City of Sydney

23 August 2010

STAGE 2A(i) CITY EAST ZONE SUBSTATION PROJECT (Application: 10_0071)

5.2.4. Basement Level 03 Plan

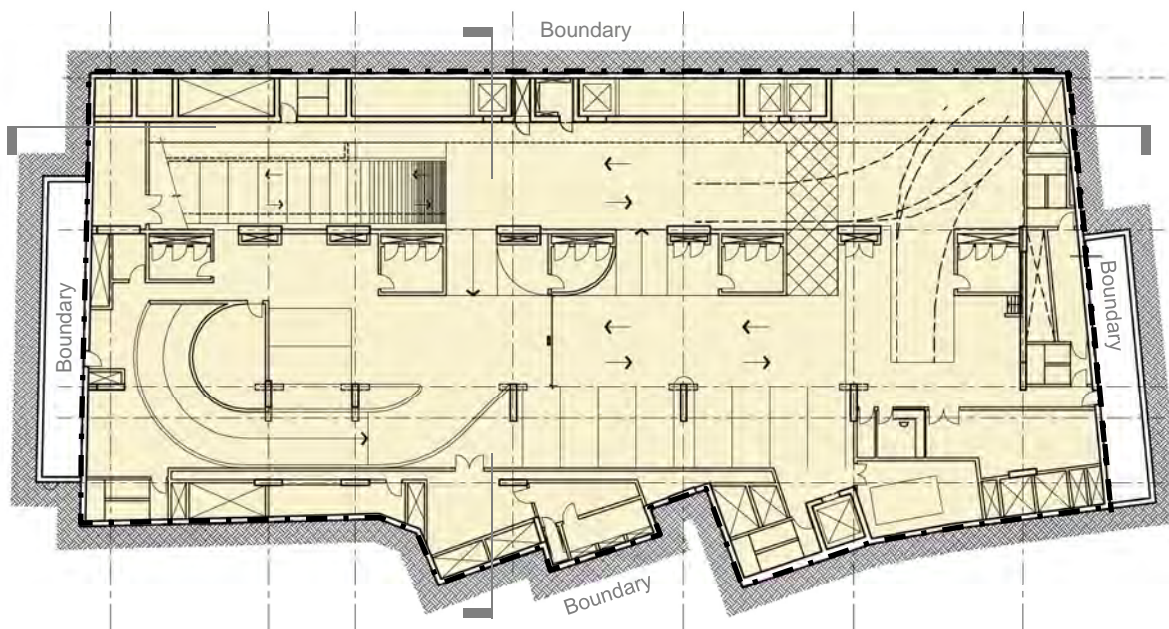
- (s) The layout provided for Basement Level 03 shows a two way blind aisle with no dedicated turning area. The applicant must address this issue in their application for the approval of this parking level.

- (t) The layout provided for Basement Level 03 shows the adjacent one way circulation path entry point at the top of the ramp. In the detailed application of this the applicant will need to address the swept path here.

5.2.6. O'Connell Street Level 05 Plan

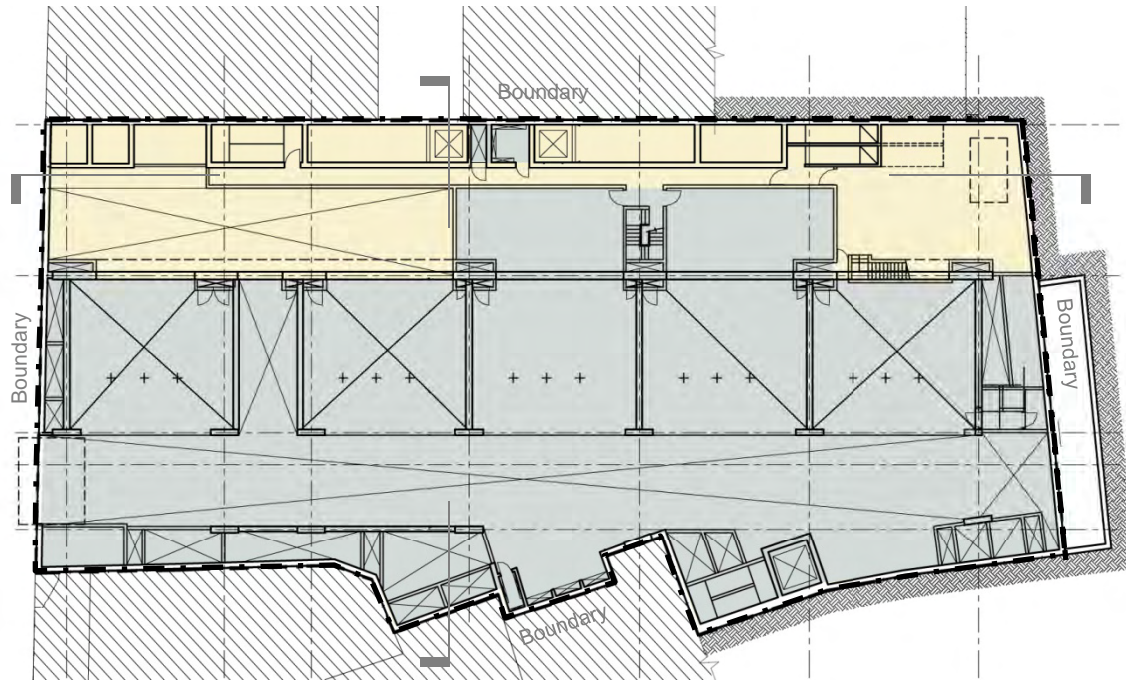
In addition, the proposed double driveway arrangement will result in further erosion of the O'Connell Street character. The requirement for this is discussed below, under 'Traffic'.

The plan appears to show two driveways along the O'Connell Street frontage, one for access/egress to the basement car park and another to access the substation. The applicant will need to provide details of why the driveways cannot be combined. In addition, information outlining the likely frequency of use of the second driveway is required to justify its existence. The City has a policy of trying to improve pedestrian amenity by amalgamating driveway crossovers. These issues must be addressed for the City to consider supporting the two driveways, if indeed this is the case.

- (o) The driveway must be located a minimum of 1m from the property boundary, a minimum of 2m from any other proposed or existing driveway and a minimum of 10m from the intersection of O'Connell Street and Hunter Street.

5.7.2. O’Connell Street Schematic Elevation

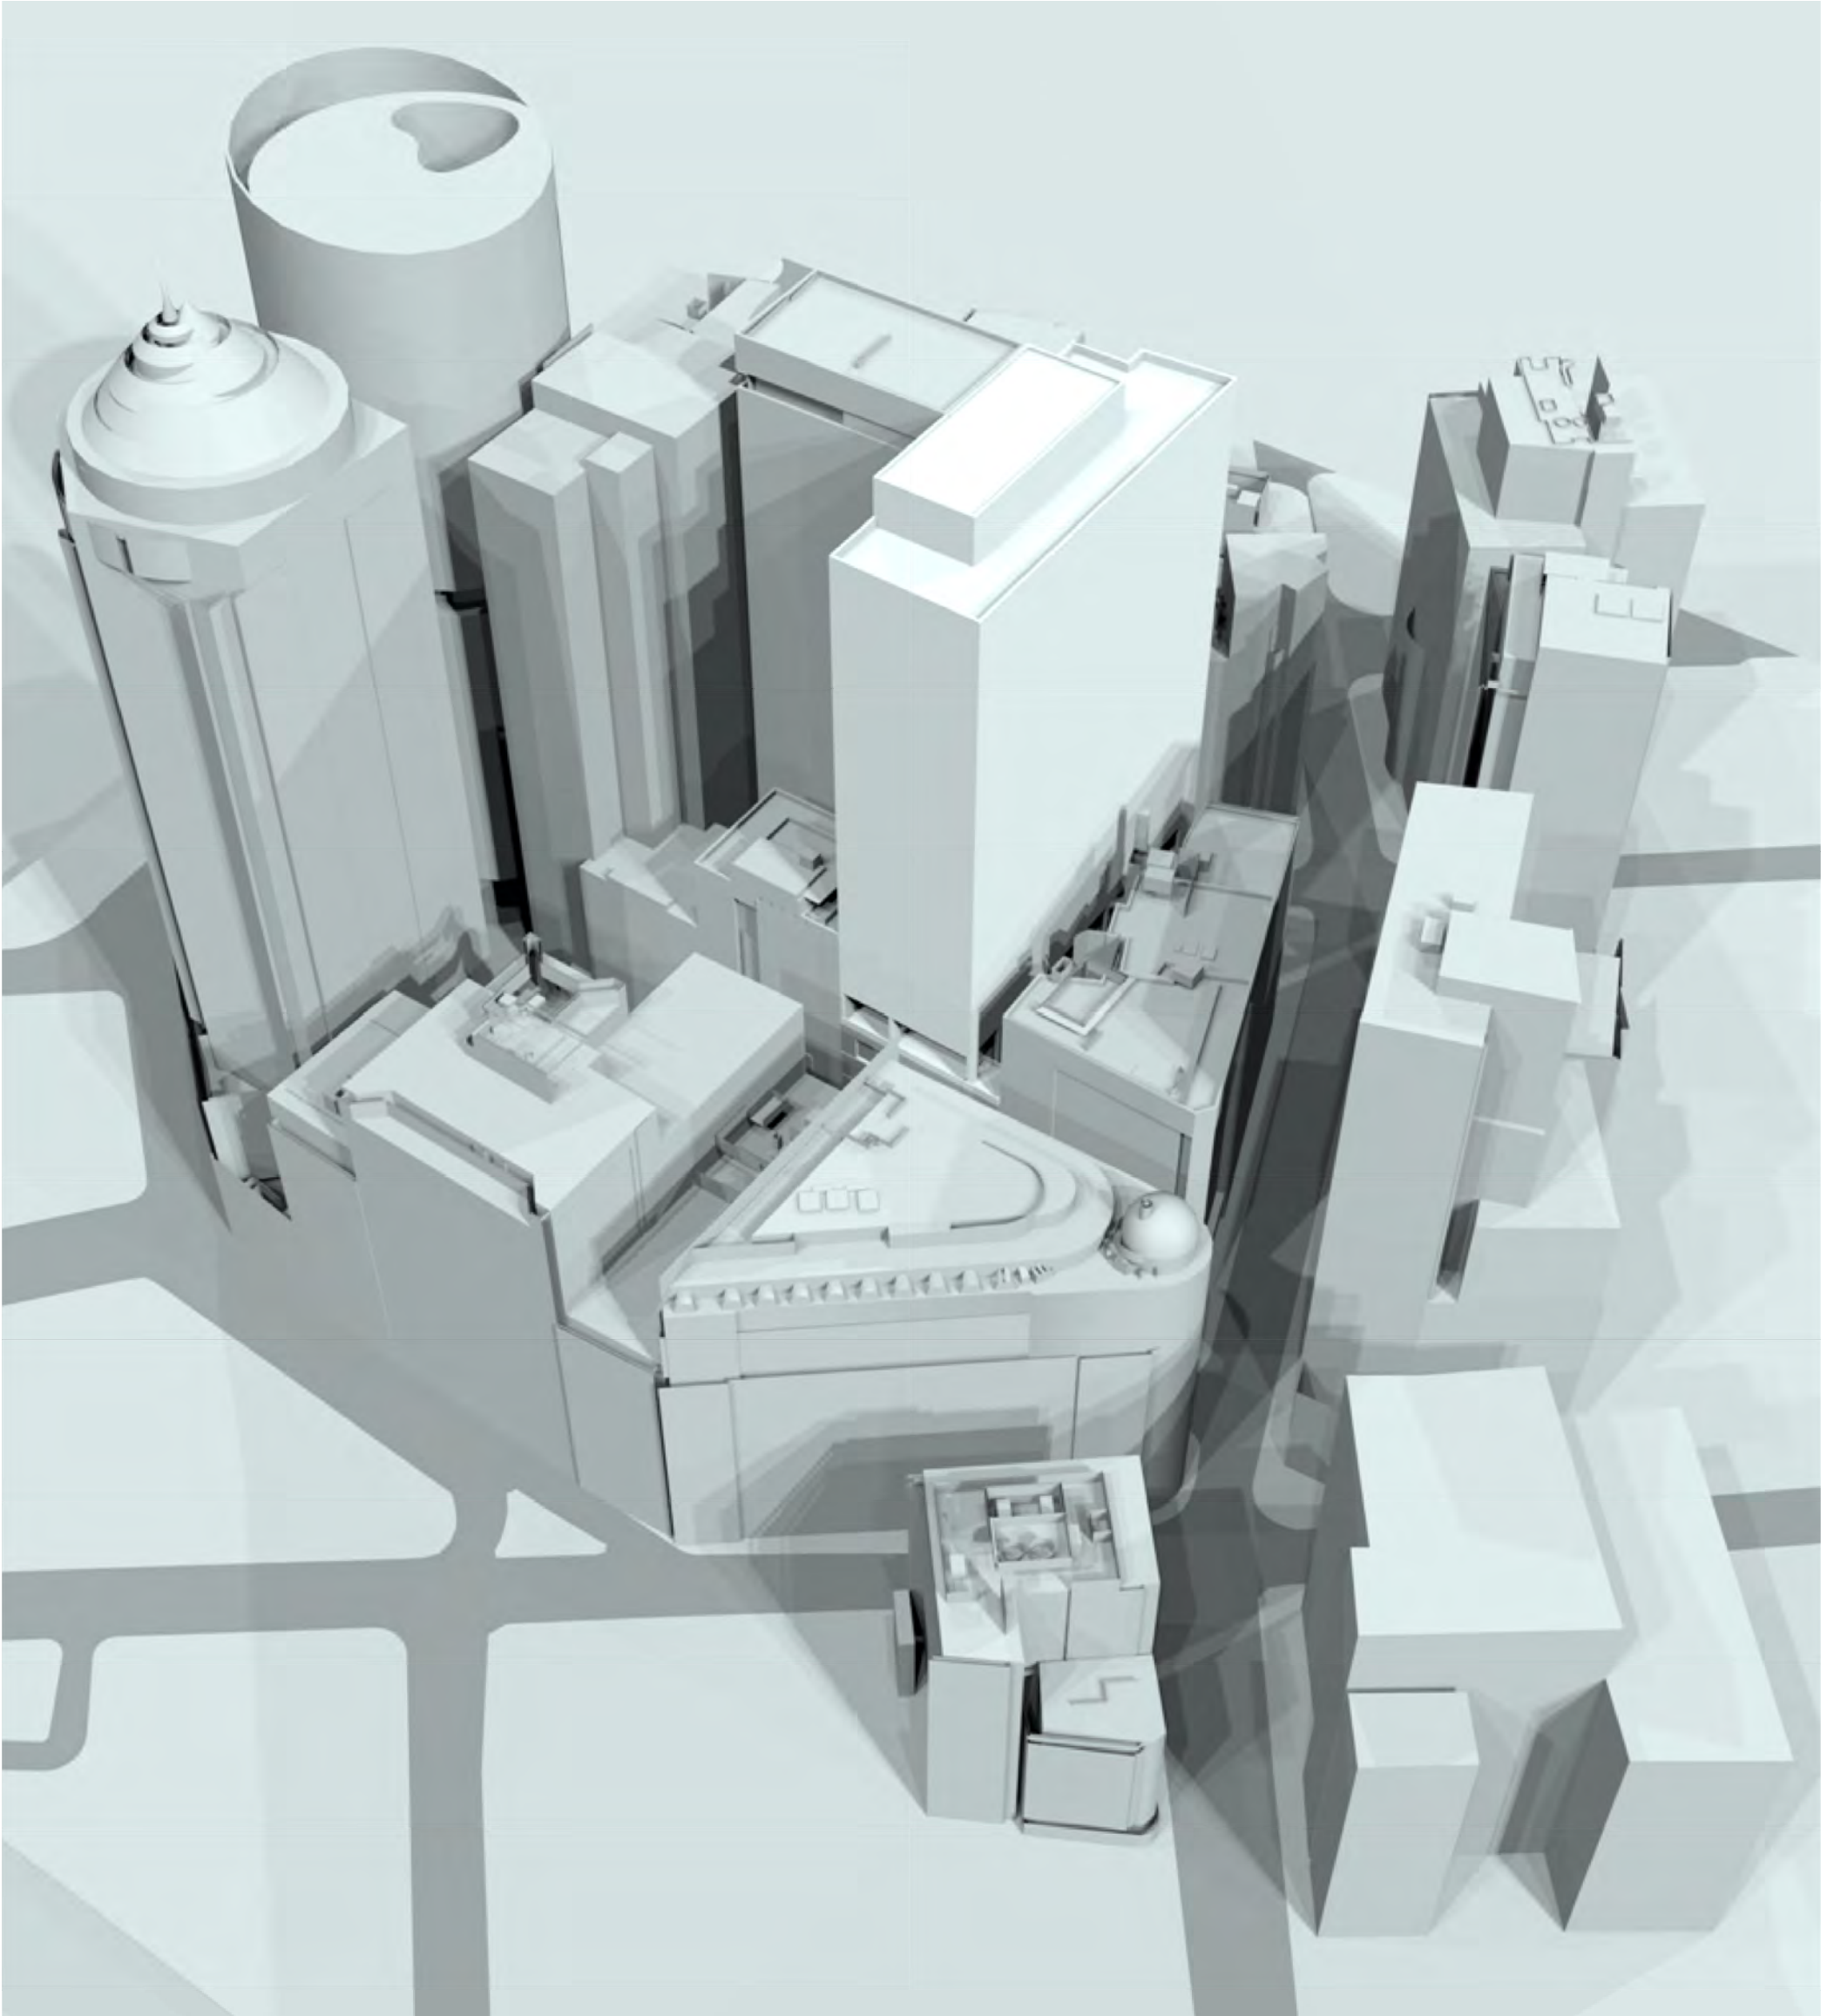
main entry being unique in Sydney. The streetscape contribution of the building to O'Connell Street is considerable yet the proposed development makes little acknowledgment of the key features of its facade particularly its striking arched base.

- A need for recognition of the scale of the arched base section of the building in the design of any attached section of the new development in relation to the lower portion of AFT House.
- The necessary use of compatible high quality materials and facade articulation, proportioning and detailing to compliment the heritage qualities of AFT House without imitating or detracting from it.

- (a) To provide articulation at street level, the base building is to be setback a minimum of 500mm from the O'Connell Street frontage above the height of the arched granite base of AFT House at 16-18 O'Connell Street.
